**Application for Approval of Details Reserved by Condition
Town and Country Planning Act 1990
Planning (Listed Buildings and Conservation Areas) Act 1990**

Discharge of conditions 3 (detailed drawings), 4 (additional storey), 5 (materials), 6 (residential waste), 7 (A3 use waste), 9 (swift nesting), 14 (ventilation), 15 (noise assessment) and 19 (air quality) of previous permission 2019/92962 for erection of additional storey and conversion of building to provide 23 self-contained apartments and A3 use in basement and part of ground floor (Listed Building within a Conservation Area)

Field House, 15 Wellington Street, Dewsbury, WF13 1BQ

Application Number: 2022/92236

DRAWING TITLE:
COMBINED MECHANICAL SERVICES LAYOUT
ROOF LEVEL

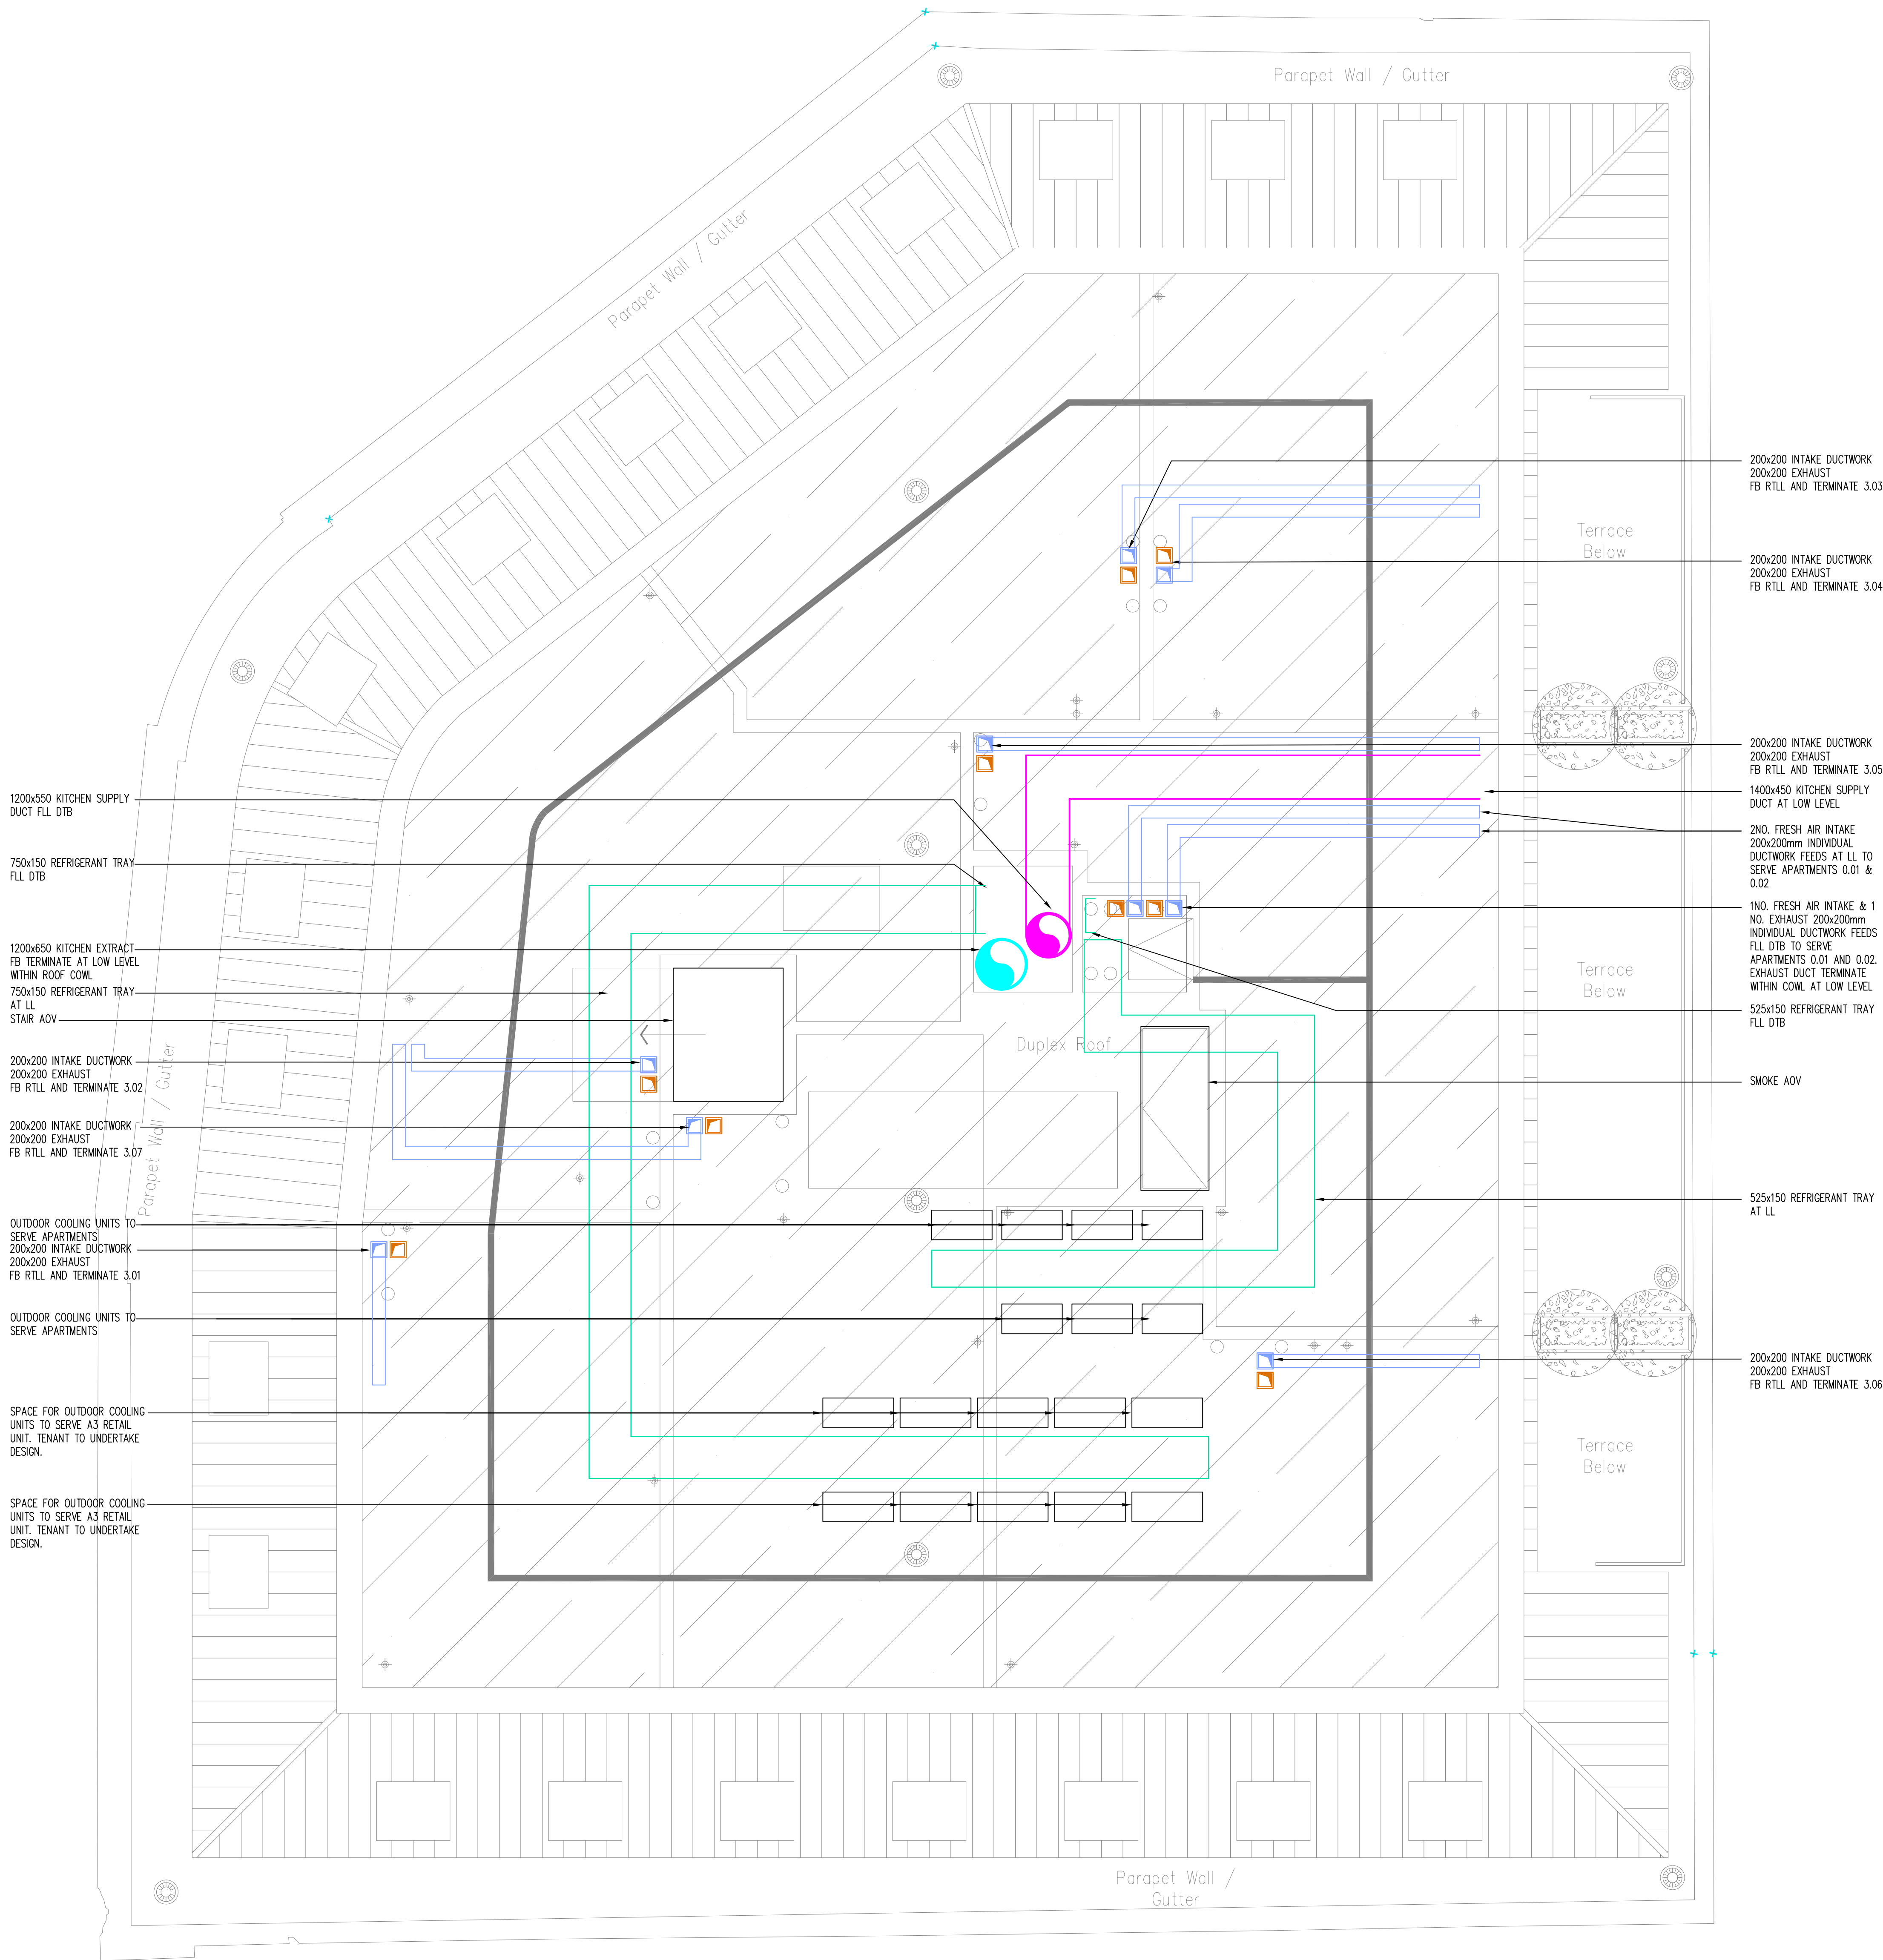
- 1441354-HLEA-XX-02-DR-M-100501 S3 rev P01
- 1441354-HLEA-XX-ZZ-DR-M-100504 S3 rev P01
- 1441354-HLEA-XX-B1-DR-M-100101 S3 rev P01
- 1441354-HLEA-XX-GF-DR-M-100102 S3 rev P01
- 1441354-HLEA-XX-01-DR-M-100103 S3 rev P01
- 1441354-HLEA-XX-02-DR-M-100104 S3 rev P01
- 1441354-HLEA-XX-03-DR-M-100105 S3 rev P01
- 1441354-HLEA-XX-03-DR-M-100106 S3 rev P01
- 1441354-HLEA-XX-RF-DR-M-100107 S3 rev P01

The information provided in the above-listed document and drawings is considered acceptable for the purpose of condition 14, on the proviso that ventilation measures would be provided for all apartments. Please also be reminded that condition 14 further stipulates that all works forming part of the approved ventilation scheme shall be completed prior to occupation of that apartment and shall be retained thereafter.

TITLE
REFUSE STRATEGY
(A3 UNIT)

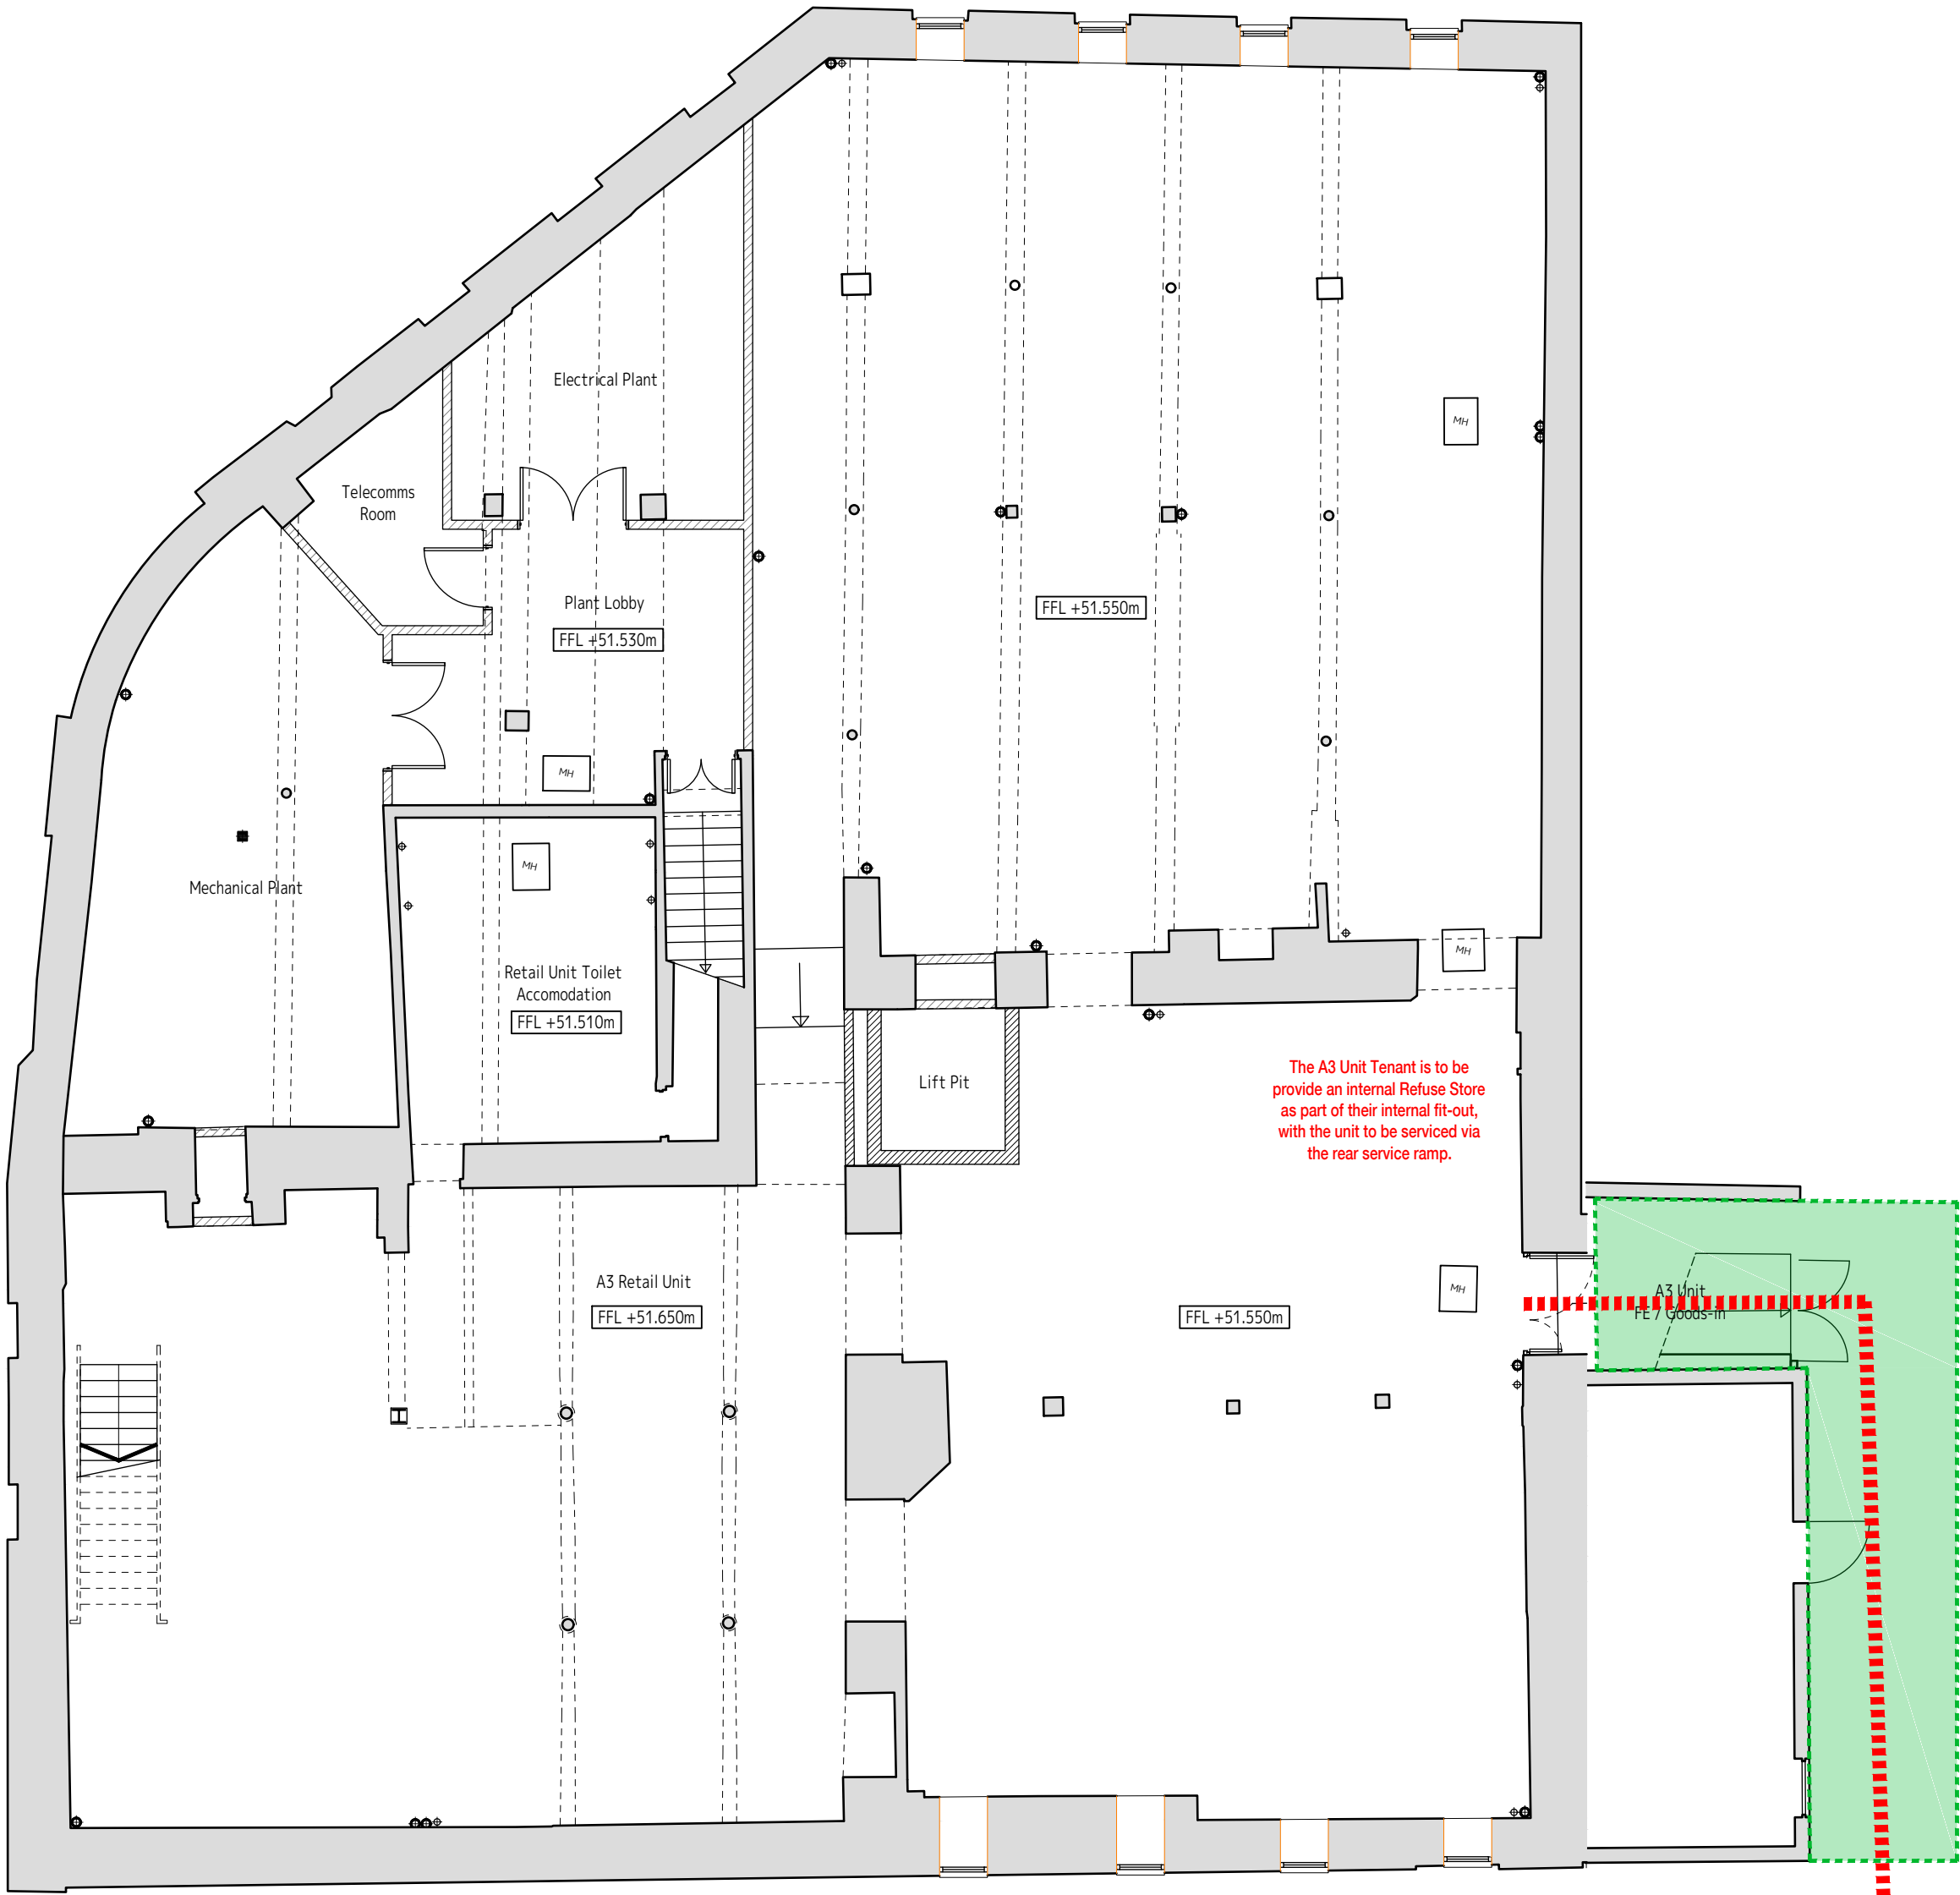
Condition 7 (A3 use waste) – You have submitted drawing 2018-051 0811 rev A titled “Refuse Strategy (A3 unit)”, and you have confirmed that bins would be wheeled out to the proposed collection points and back again by the tenant of the A3 unit on the day of collection. These arrangements are considered acceptable, and are hereby approved pursuant to condition 7. Please be reminded, however, that condition 7 further stipulates that the approved details shall be implemented prior to first occupation of any part of the A3use hereby approved, and shall be so retained thereafter unless otherwise agreed in writing by the Local Planning Authority.
